The Planning Inspectorate
Yr Arolygiaeth Gynllunio

Acceptance of Applications Checklist

East Anglia TWO Offshore Windfarm Section 55 Acceptance of Applications Checklist

Land Plans (Onshore)
Sheet Number: Sheet 2 of 12

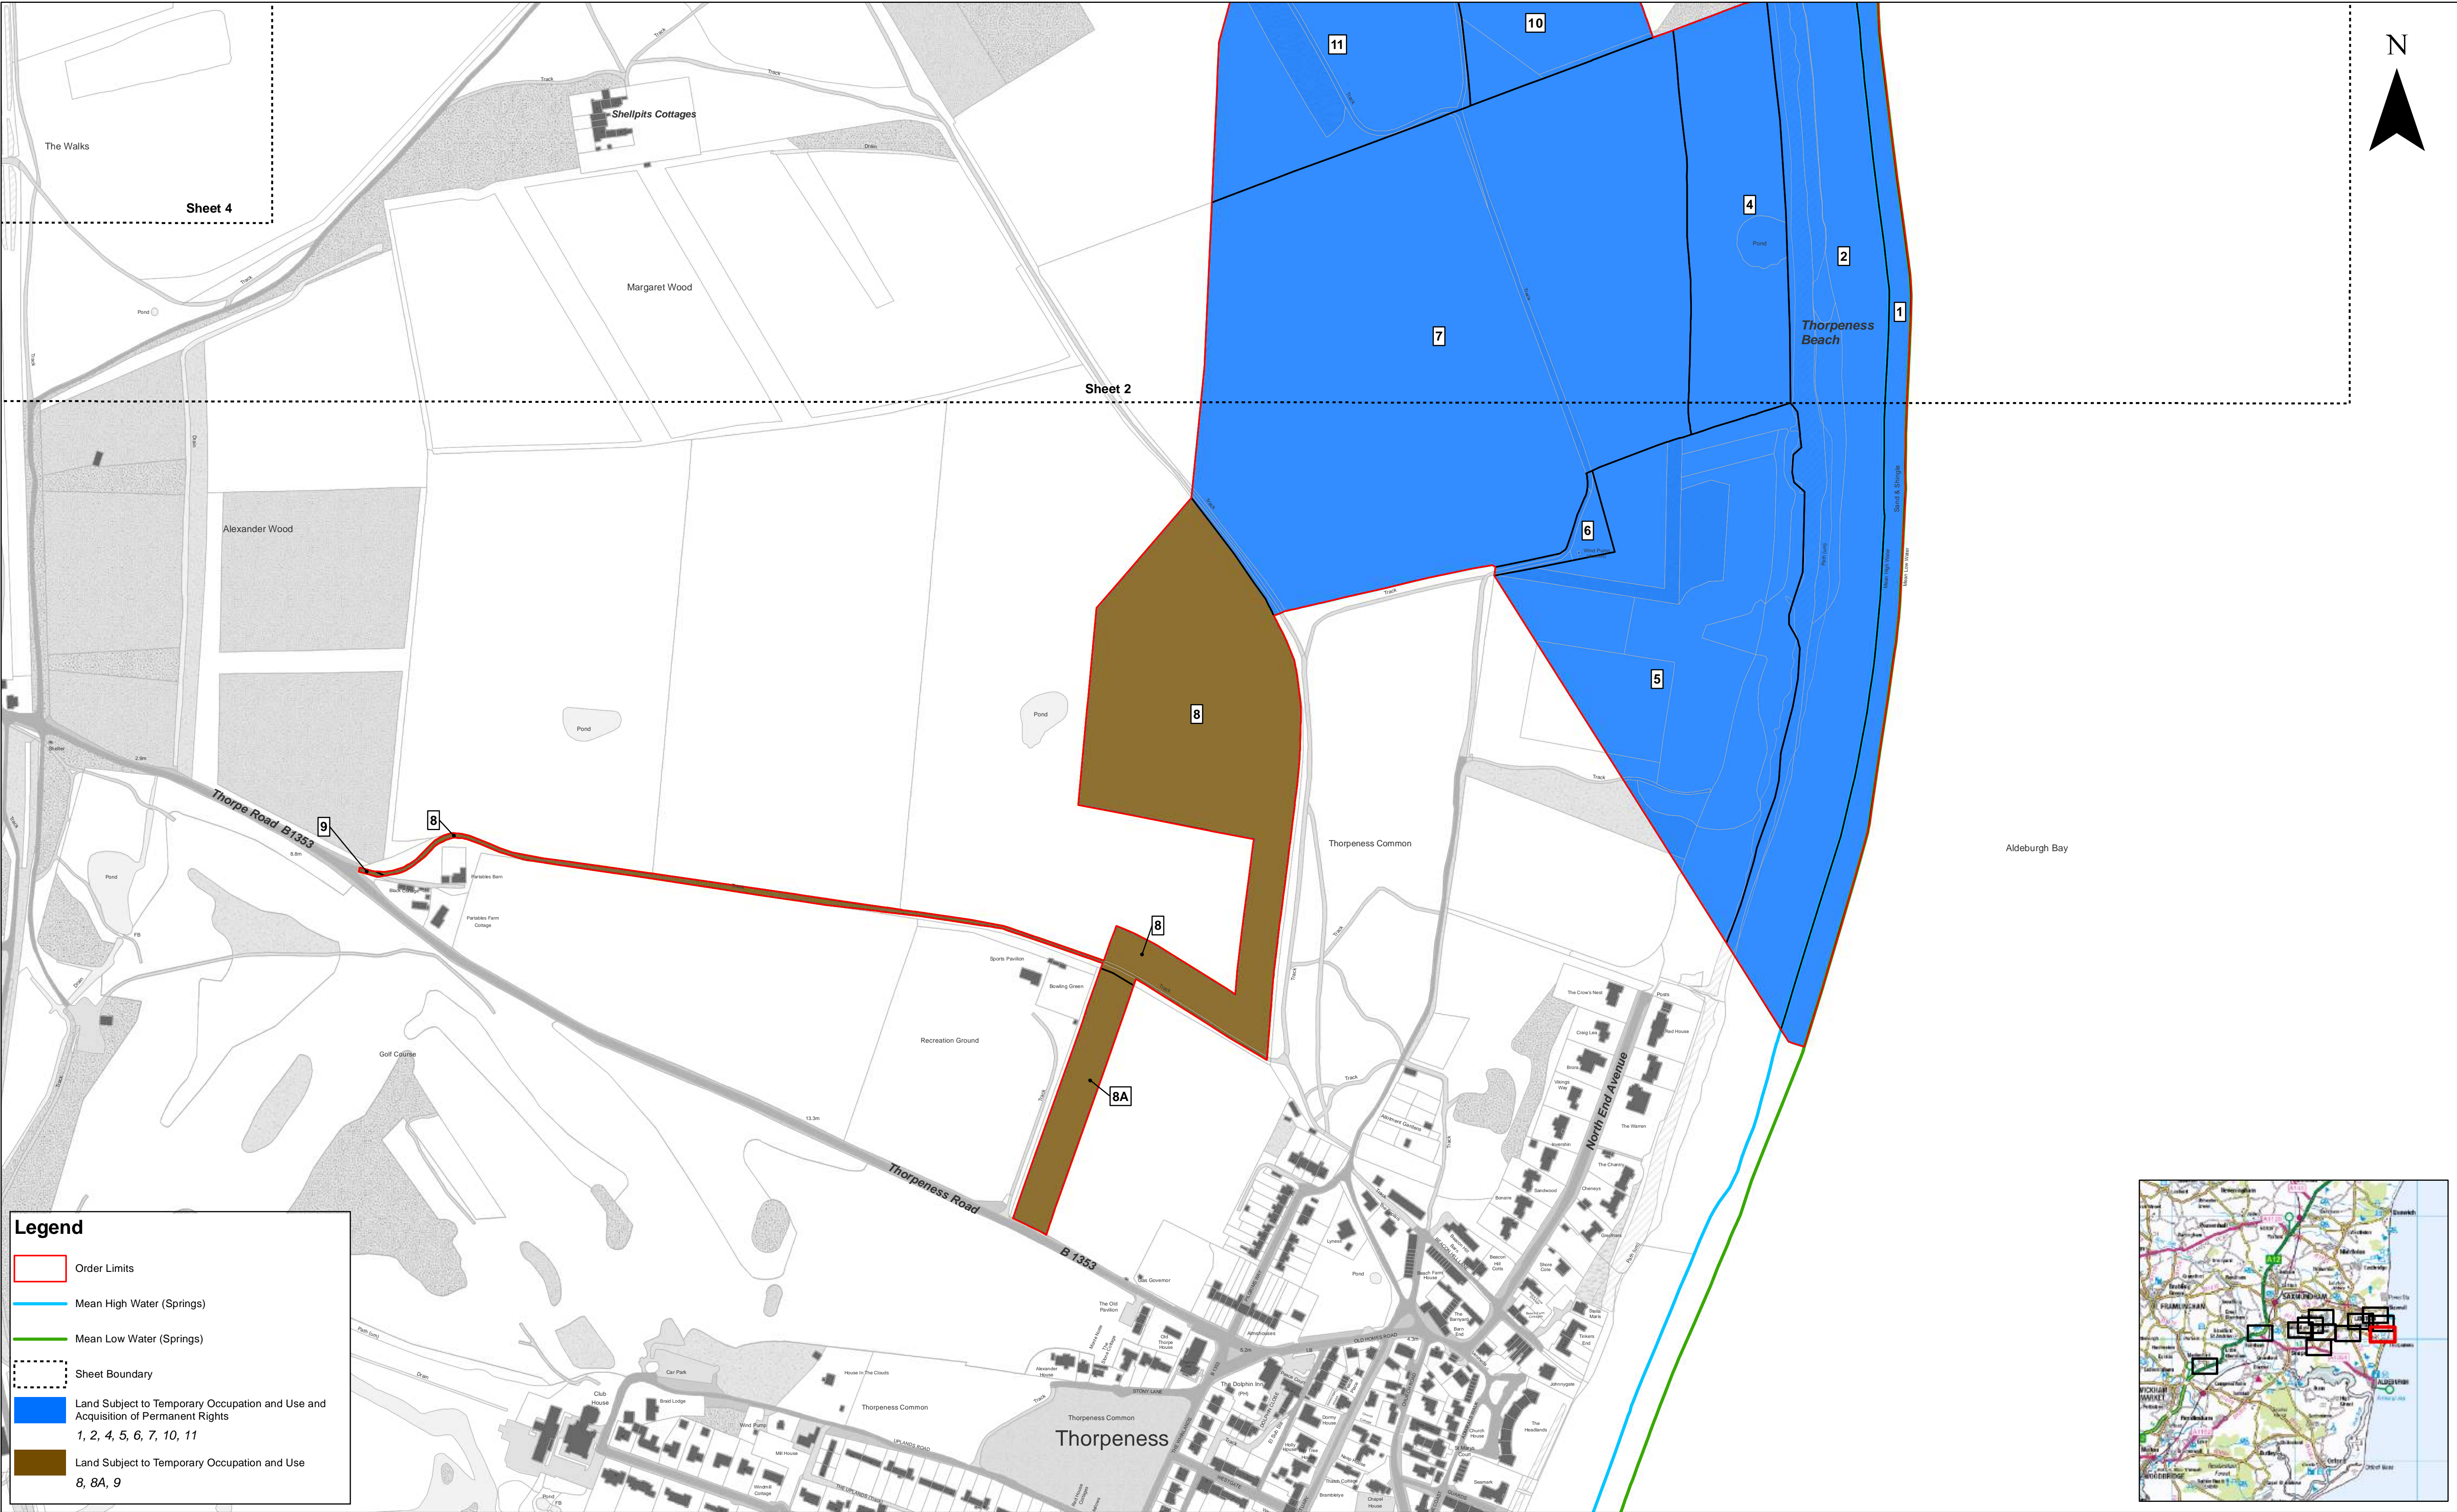
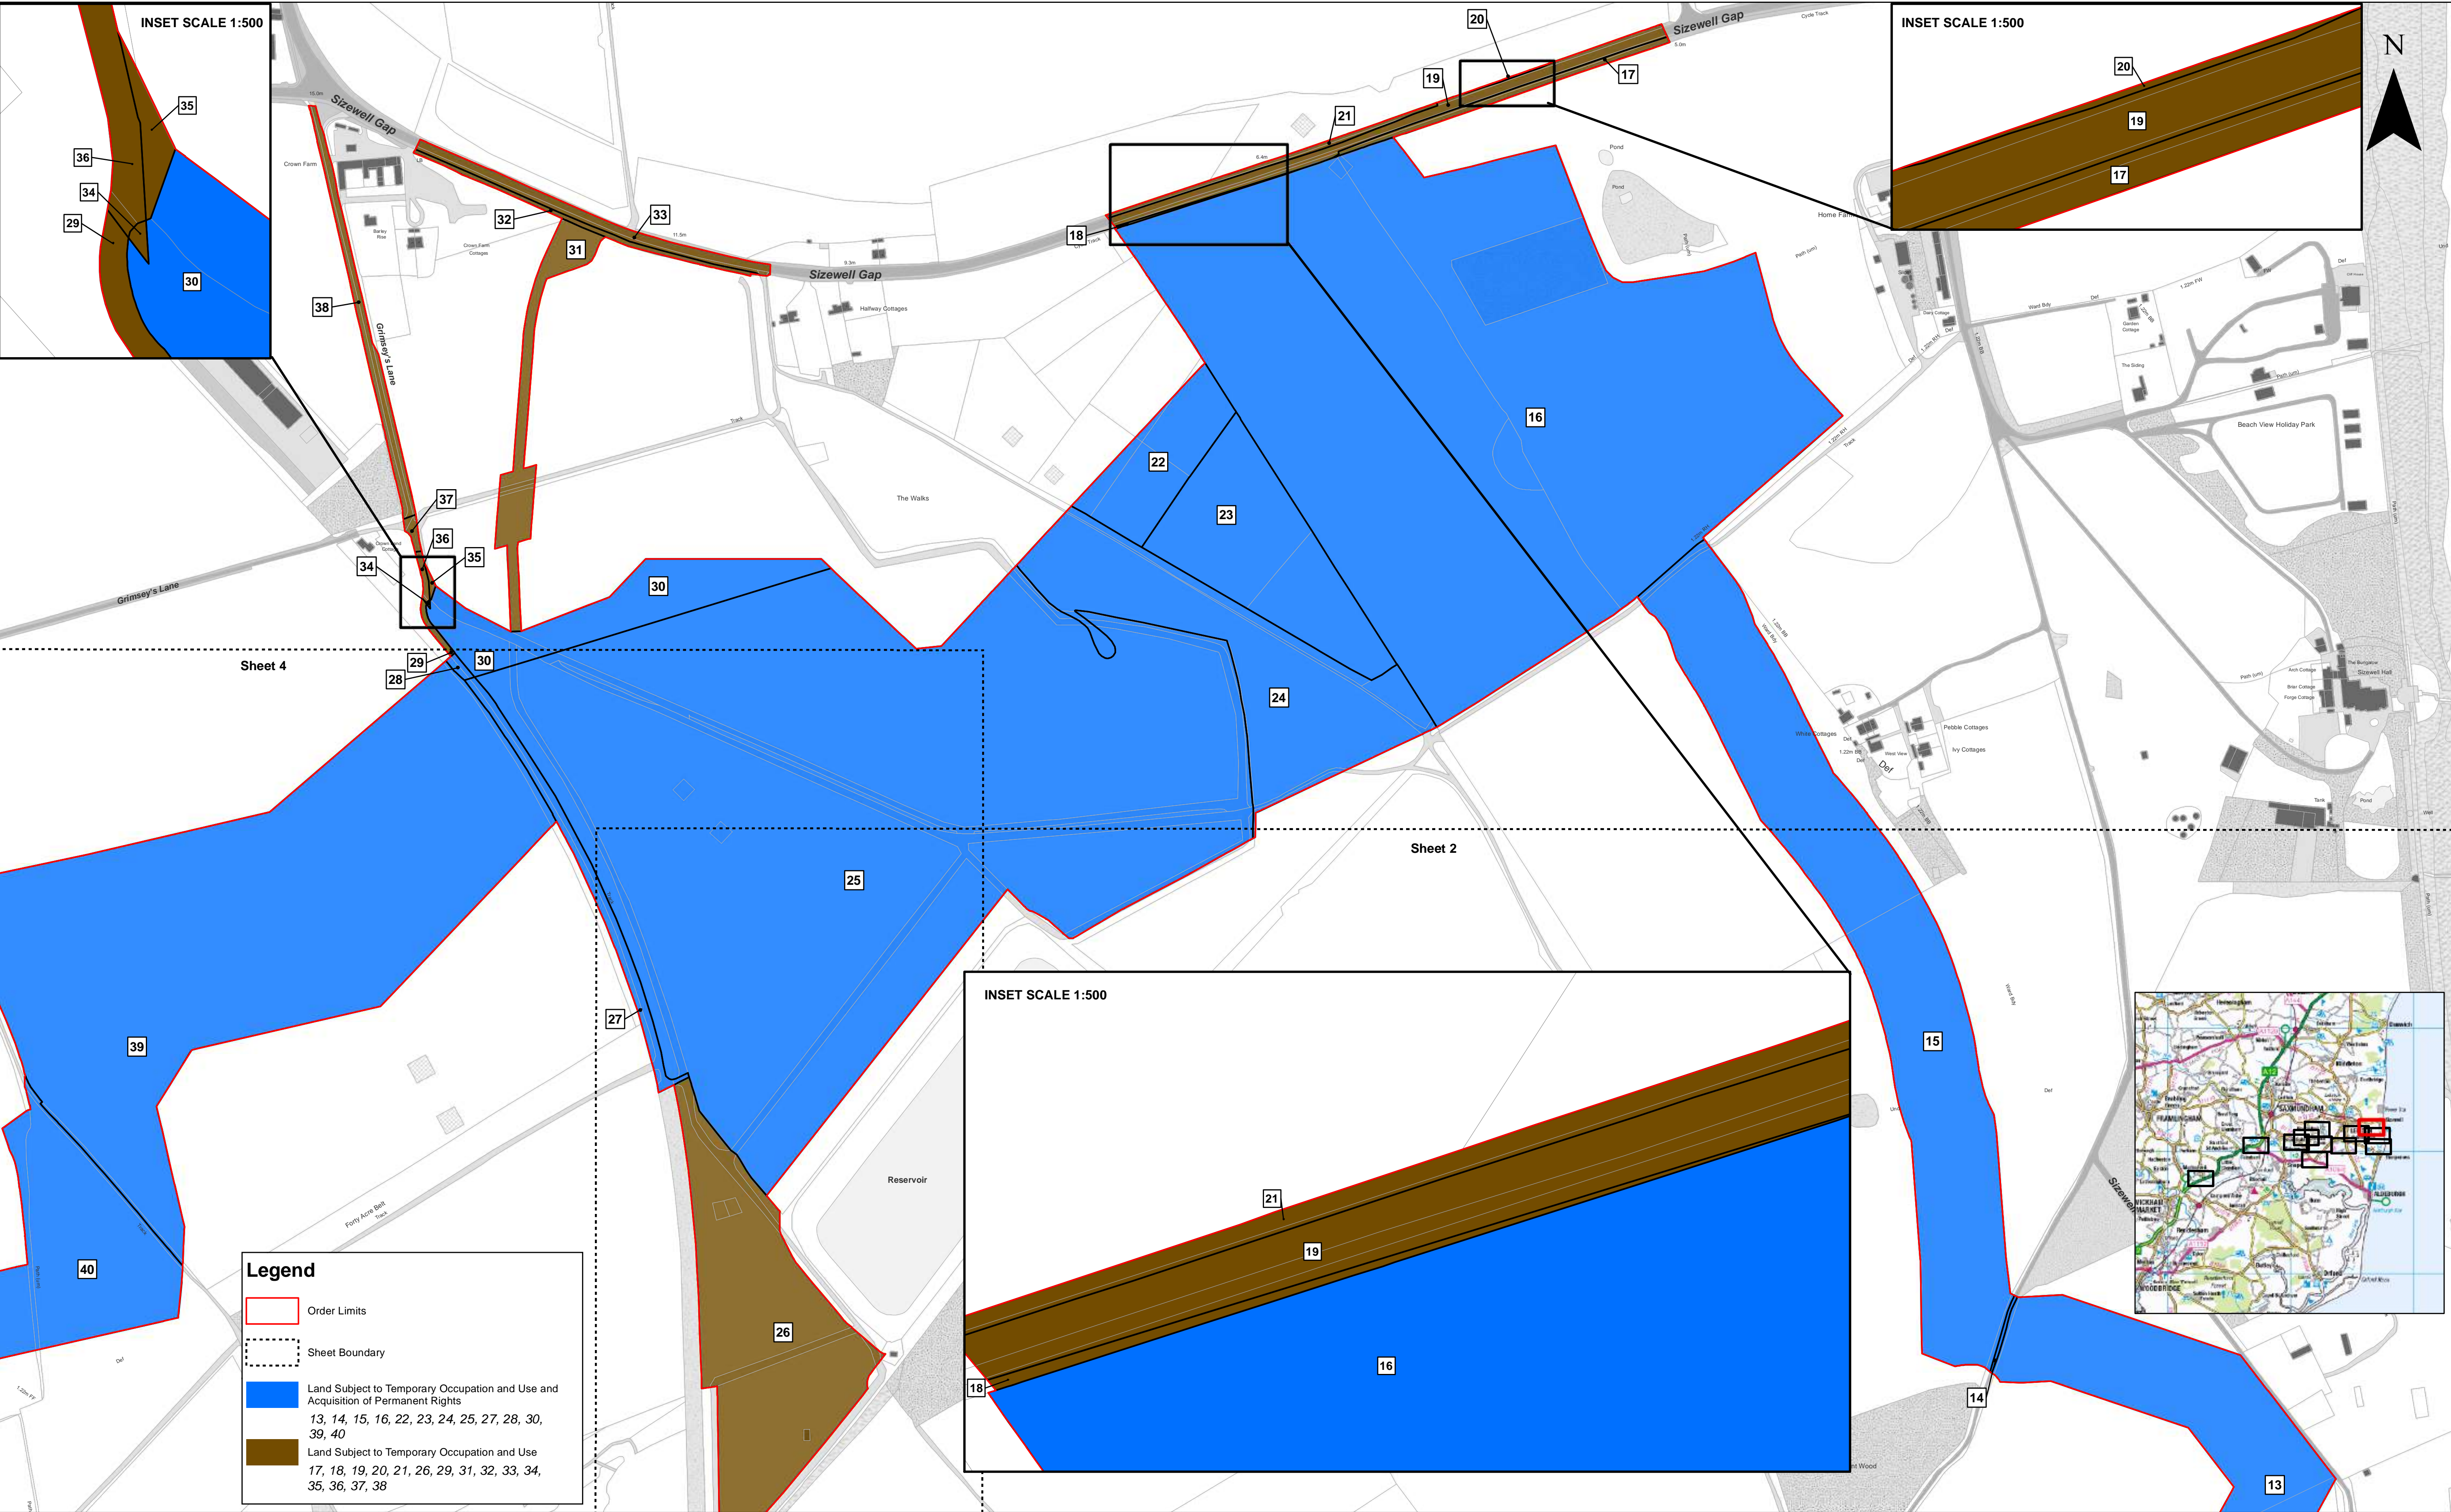
- A separate key plan has not been submitted under APFP Reg 5(4). The **Land Plan (Doc 2.2)** comprises 13 sheets. Sheet 1 is labelled as Land Plans sheet 1 of 13. This appears to be a Key Plan (though not labelled as such) which shows the relationship between the different sheets. It also shows Sheet 2 and Sheet 3 which are sectional type key plans. The individual Land Plan sheets run from Sheet 4 – 13. The Land Plan set does not utilise the same map base as the other submitted plans and the sheet layout is different.

- Not all of the names used to describe the location of land in the Book of Reference are noted on the Land Plan, ie Sizewell Estate, Sizewell Gap, Grimsey's Lane, Blackheath Estate, Redhouse Farm and Knodishall Hall.

- Road names are an important aid to the identification of land and should be larger and clearer.
- The description of Plot 65 in the Book of Reference is 'west of Fitches Lane'. Plot 65 appears on the plan to be southeast of Fitches Lane. The same issue is noted for Plot 66.
